Maritime &
Coastguard
Agency

Your ref: EN010080
Our ref: Hornsea 3

6th November 2018

**The Planning Act 2008 – Section 89 and The Infrastructure Planning
(Examination Procedure) Rules 2010 – Rule 8**

Hornsea Project Three Offshore Wind Farm Works Plan - Offshore Sheet 1

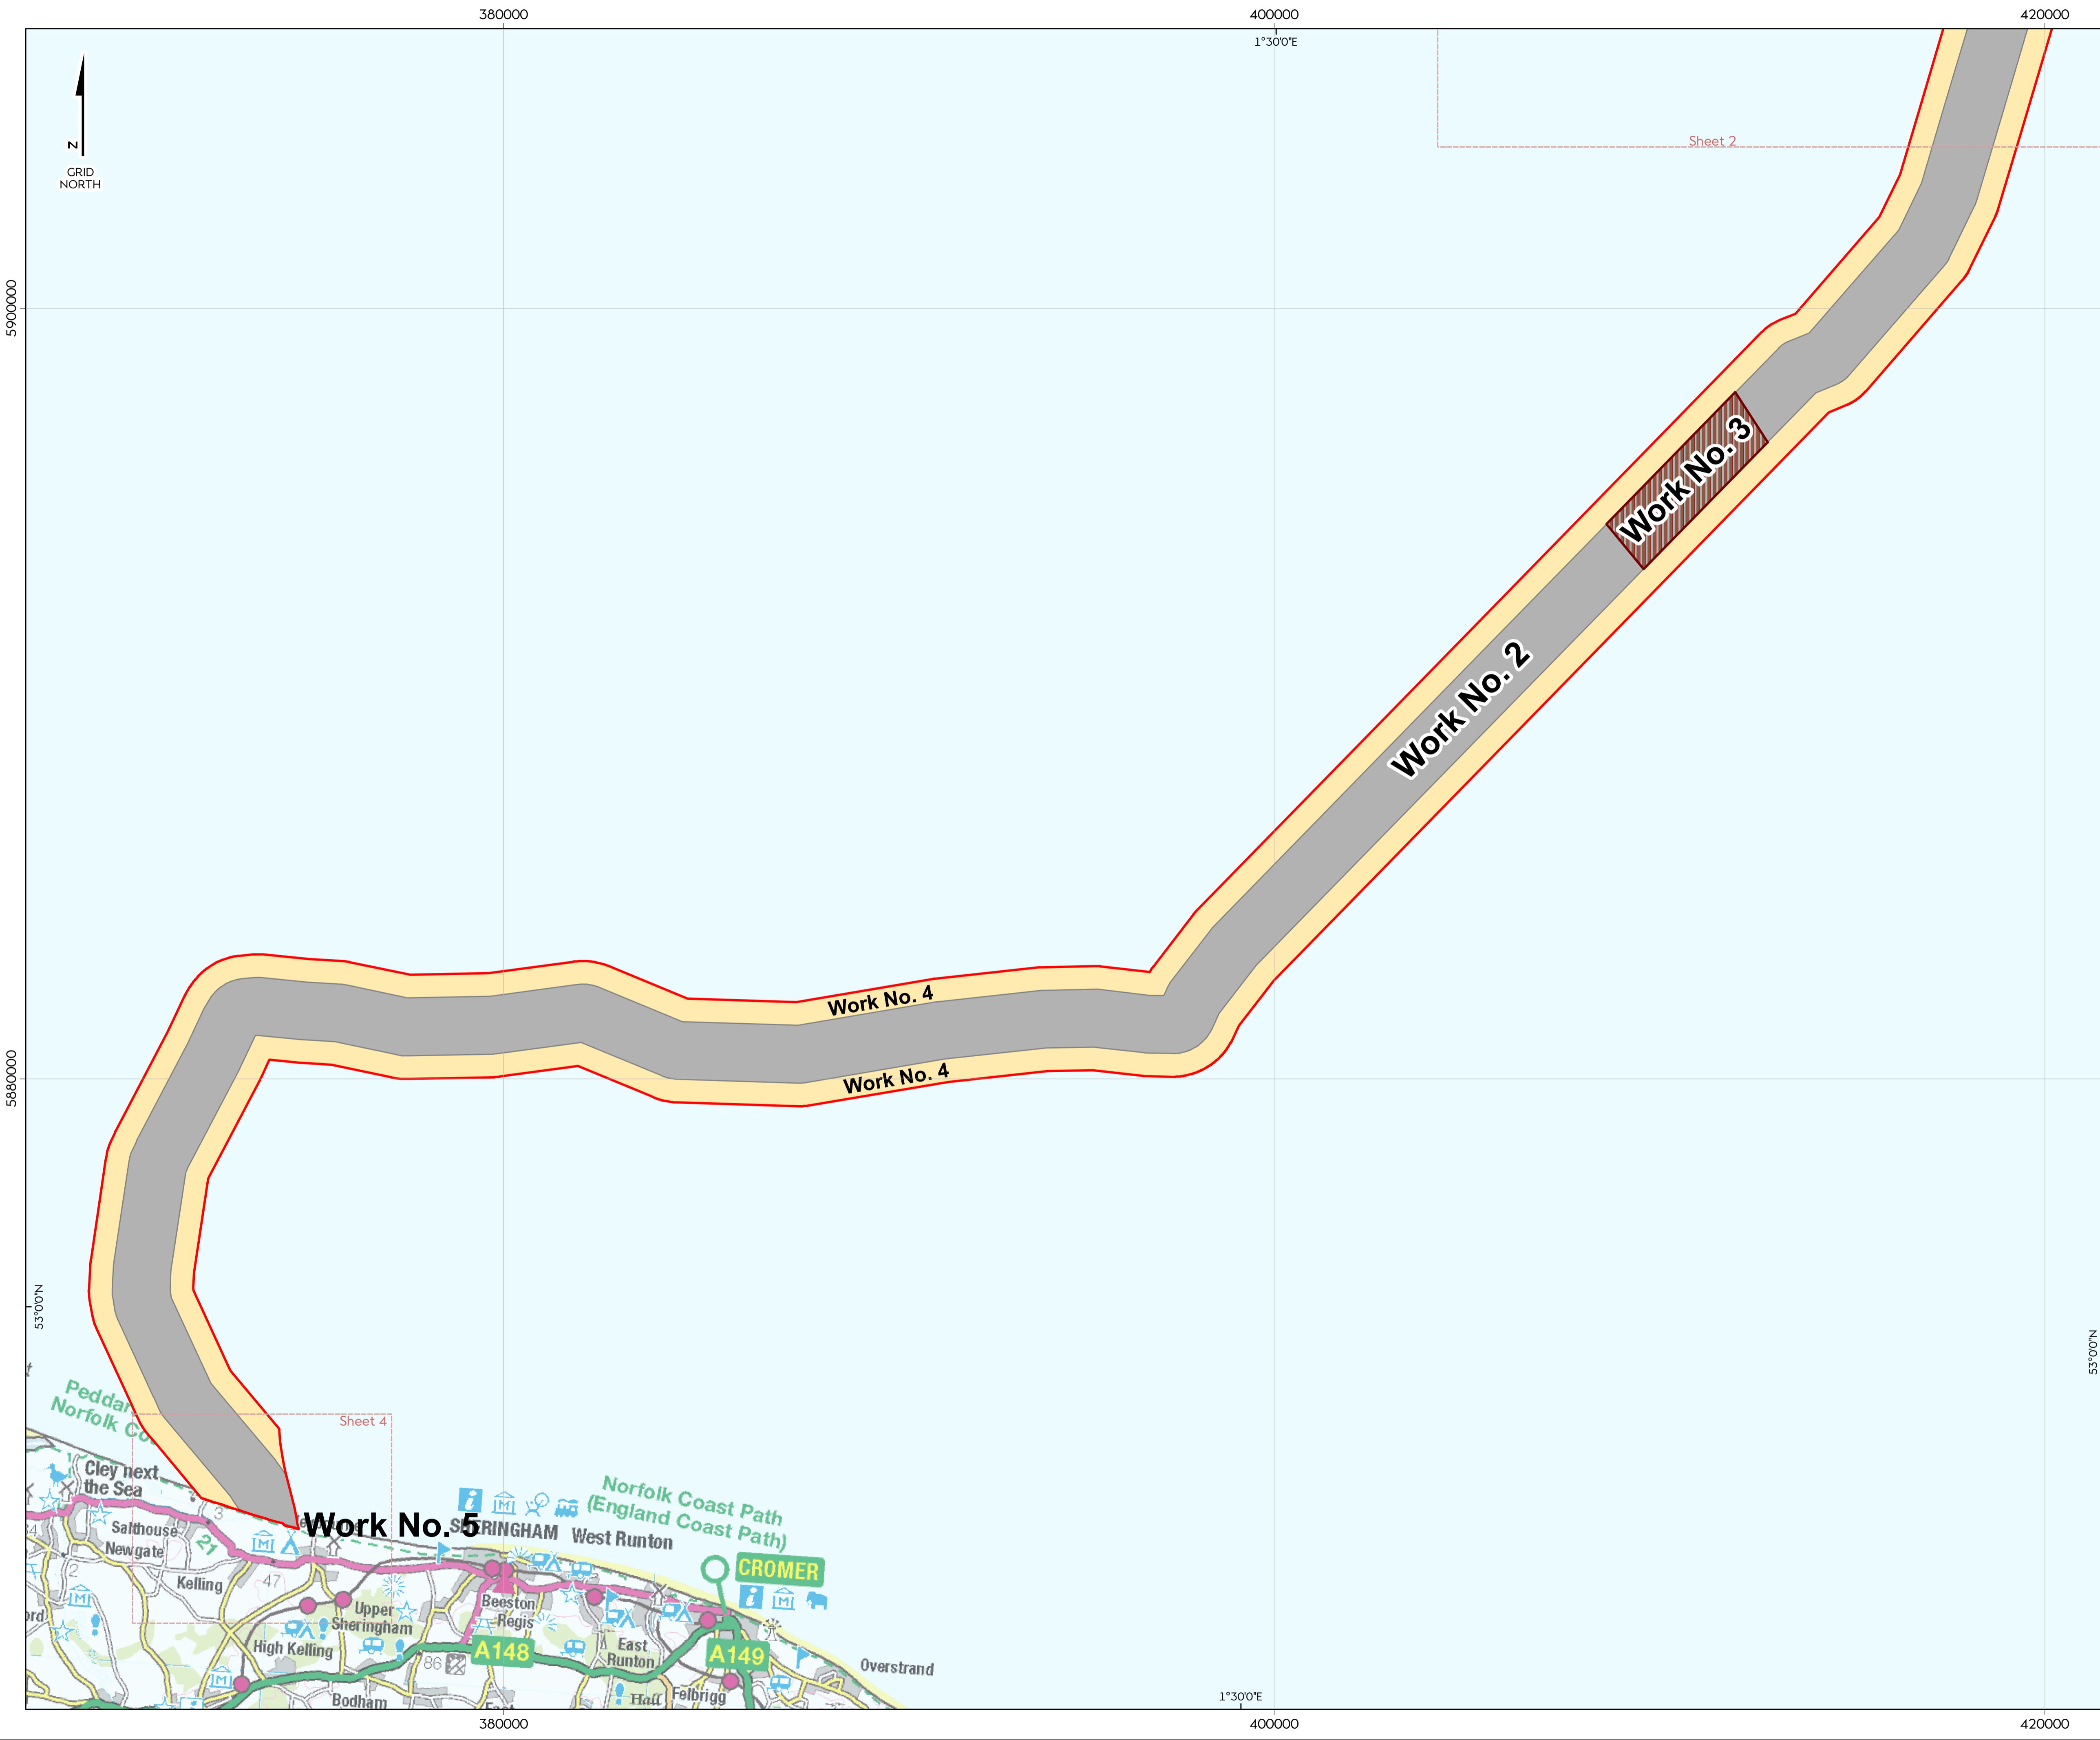
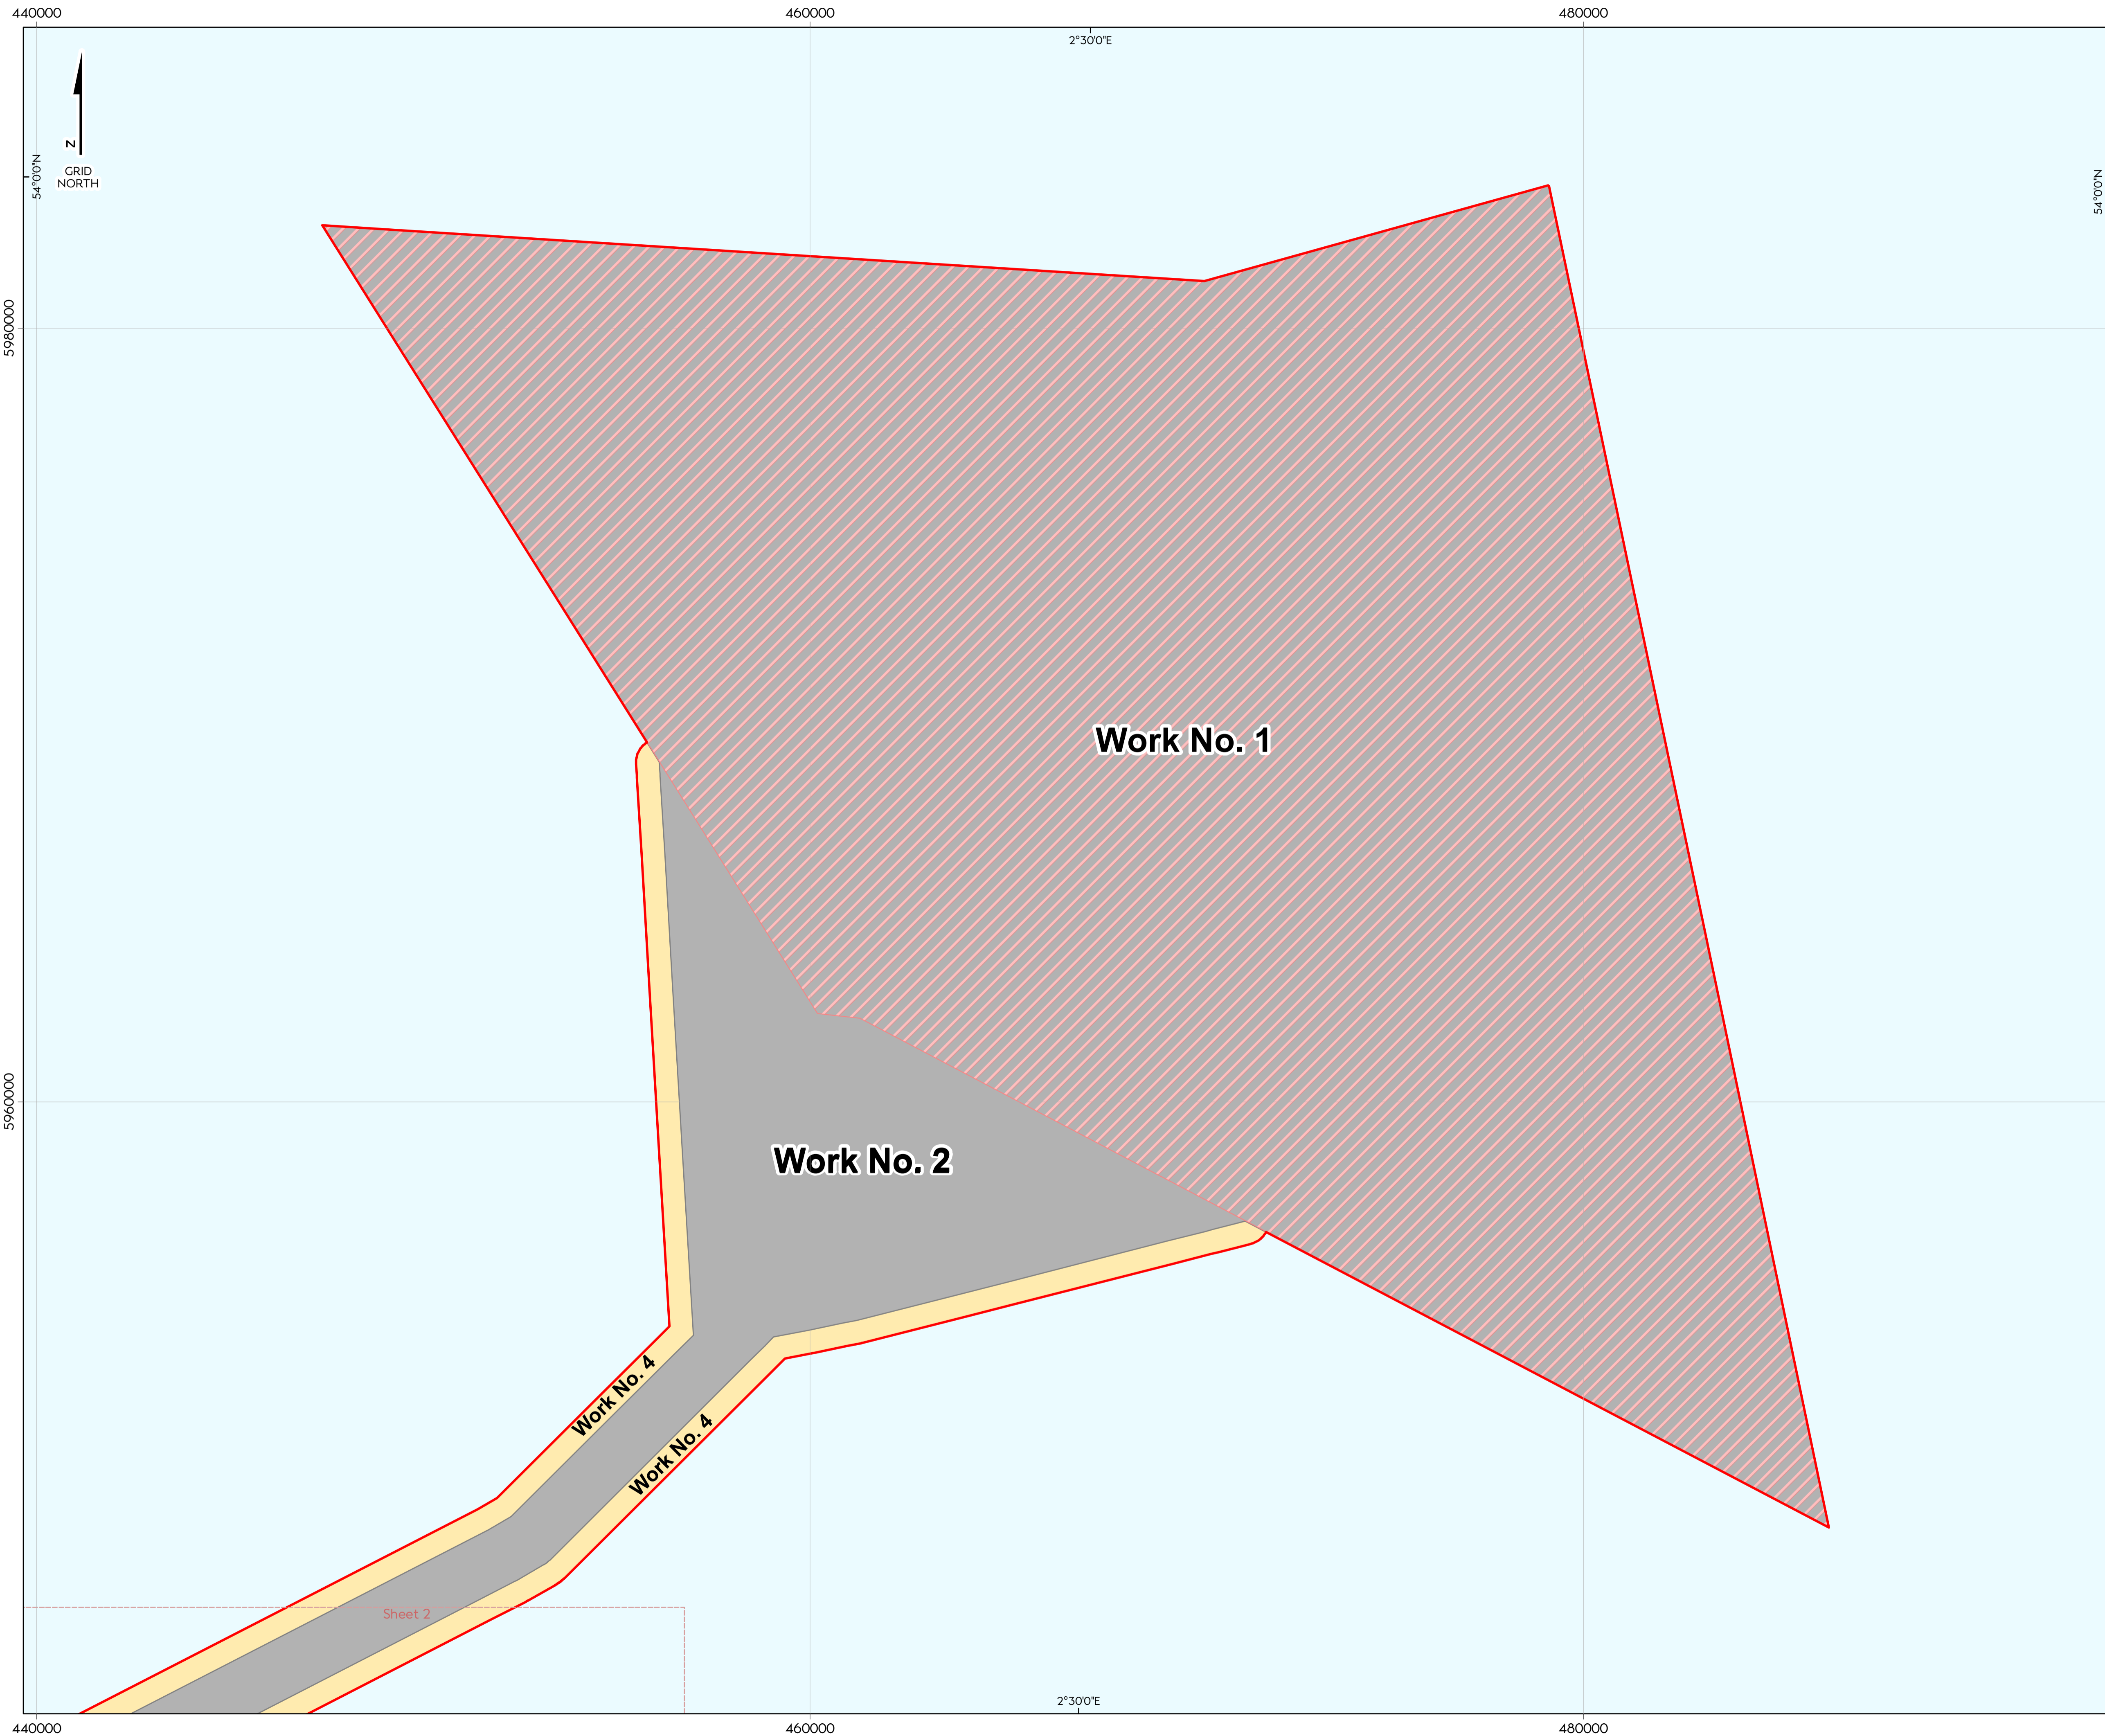
This increase in risk is only tolerable with the appropriate risk mitigation as detailed in the Navigation Risk Assessment, and a layout of wind turbine generators (and other associated windfarm infrastructure) which is in accordance with our Marine Guidance Note (MGN) 543. The layout is of significant concern for MCA going forward, and the design principles have not yet been agreed by MCA. Although we support the establishment of the design principles, we should not be held to account should we not have considered every possible future eventuality based on the information provided within the current design principles.

Therefore, the MCA requests the option and ability to consider any layout plans on a case by case basis in line with MGN 543. This includes our strong recommendation that at least two lines of orientation are included within the layout design. This is not only for search and rescue purposes; multiple lines of orientation provide alternative options for vessel passage planning. We know that by far the safest way to navigate through a windfarm is when the turbines are in straight lines, with multiple lines of orientation, which gives a clear line of sight of entry and exit. If a master/skipper decides to go through a windfarm, they tend to place themselves equidistant between the turbines on either side, and this helps counter the environmental effects on handling, and this is compromised with a random turbine layout.

The MCA request that turbines are constructed in straight lines, with a minimum of two lines of orientation, to maintain the safety of navigation and our search and rescue obligations. Access to windfarms by helicopter and vessels during an emergency situation, and by vessels should they decide to transit through a windfarm, is a complex process, especially in poor weather conditions, and therefore mitigations are required to ensure it is as safe and feasible as possible.

Standard search patterns are linear to allow for an effective coverage of an area, and wind turbines will degrade the search capability by restricting search spacing and increasing crew workload - therefore reducing search effectiveness. Within Principle 8, the developer may build turbines in an irregular layout anywhere within that 300m corridor, which would significantly impact the ability to search and/or rescue.

As a result, the MCA would be content with a tolerance of 50m with the understanding that the developer aims to construct turbines along the centreline and only deviating if conditions/seabed do not allow for a straight line.

As raised in response to Q1.5.4 access into windfarms is complex, and the MCA must maintain the capability to deliver an effective SAR service anywhere within the UK Search and Rescue Region. A SAR lane which is of significant length (c10nm) is a concern as it limits the manoeuvring options for a helicopter whilst in the lane, e.g. when the aircraft can either climb out of, or transit to the end of the lane before making a turn and continuing its search. For a lane of 10nm, it would take 12 minutes before the helicopter could change track at ~50kts, which is a significant amount of time during an emergency situation. For Hornsea Three, at least one of the proposed lanes was in excess of 20nm.

- 1) it can allow additional routes into a windfarm improving the access options;
- 2) it allows for an area in which the helicopter can turn along a search leg, so an aircraft doesn't necessarily have to climb out and go back to the start of the next lane; and
- 3) it also allows for a 'safe' area for an aircraft to re-familiarise with the surroundings, re-orientate their position within the windfarm or during an aircraft emergency. This is a fundamental requirement when windfarms are over c10nm and is particularly important when there is less than two lines of orientation.
